# *City of Albuquerque*

July 8, 2004

**RE: Cottonwood Crossing Phase II Lot 2  
Grading and Drainage Plan  
Engineer's Stamp dated 6-8-04 (B14/D10)**

ENGINEER'S SEAL	COTTONWOOD CROSSING PHASE 2	DRAWN BY JDN	DATE 07-08-04
		2297GRB-06-02-04	SHEET # C-1
RONALD R. BOHANNAN P.E. #7868		 TERRA WEST, LLC 8509 JEFFERSON NE ALBUQUERQUE, NEW MEXICO 87113 (505)858-3100

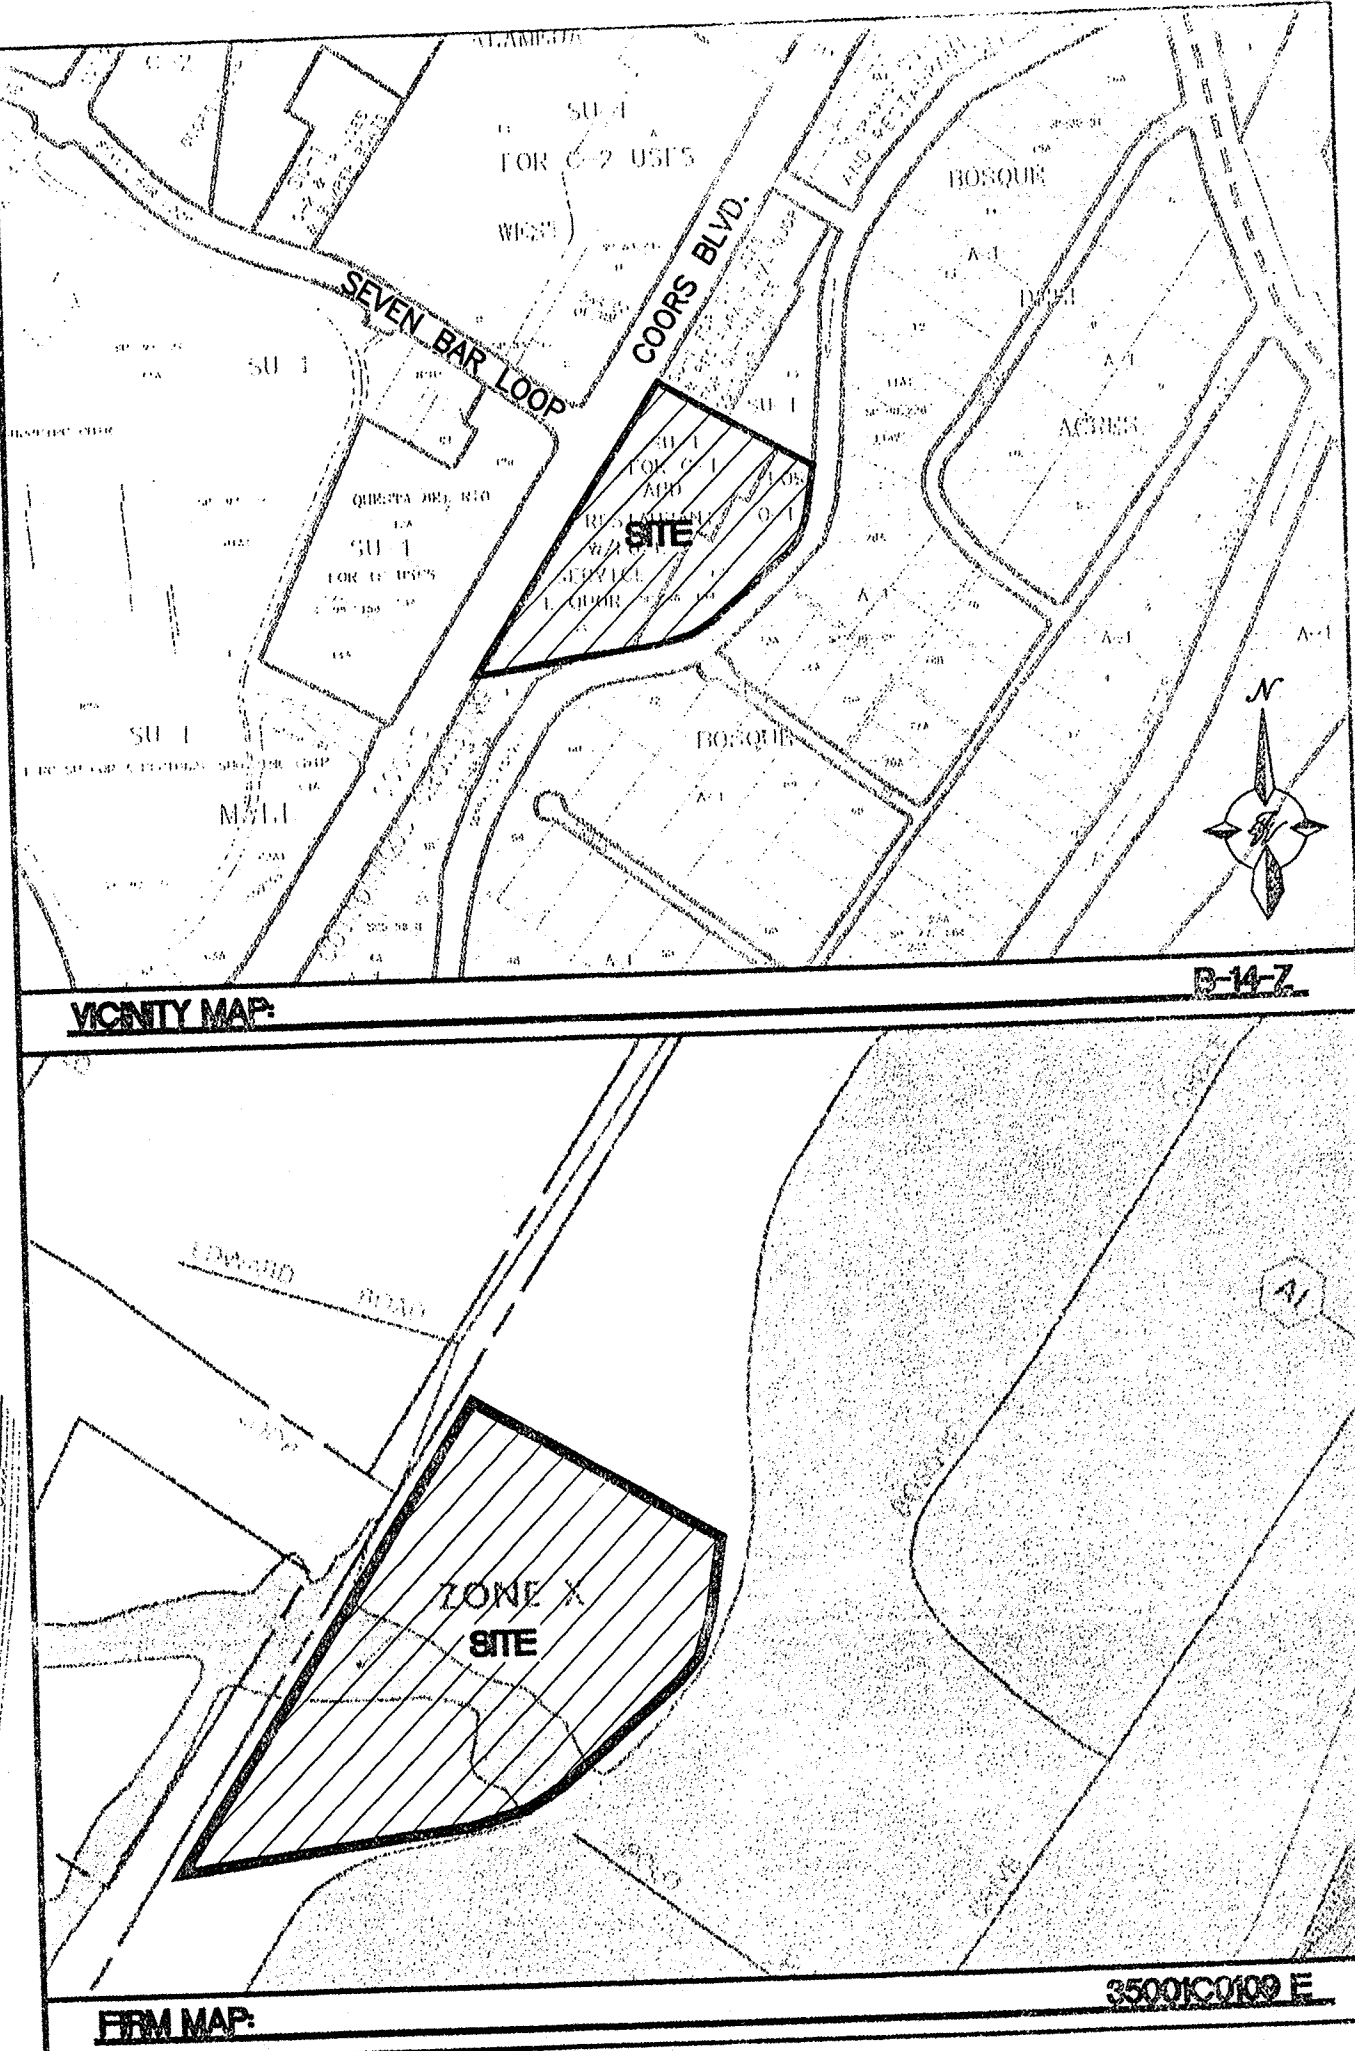
- The northernmost inlet into the AMAFCA pond should be built with Work Order, not Building Permit. Please revise the plan accordingly.
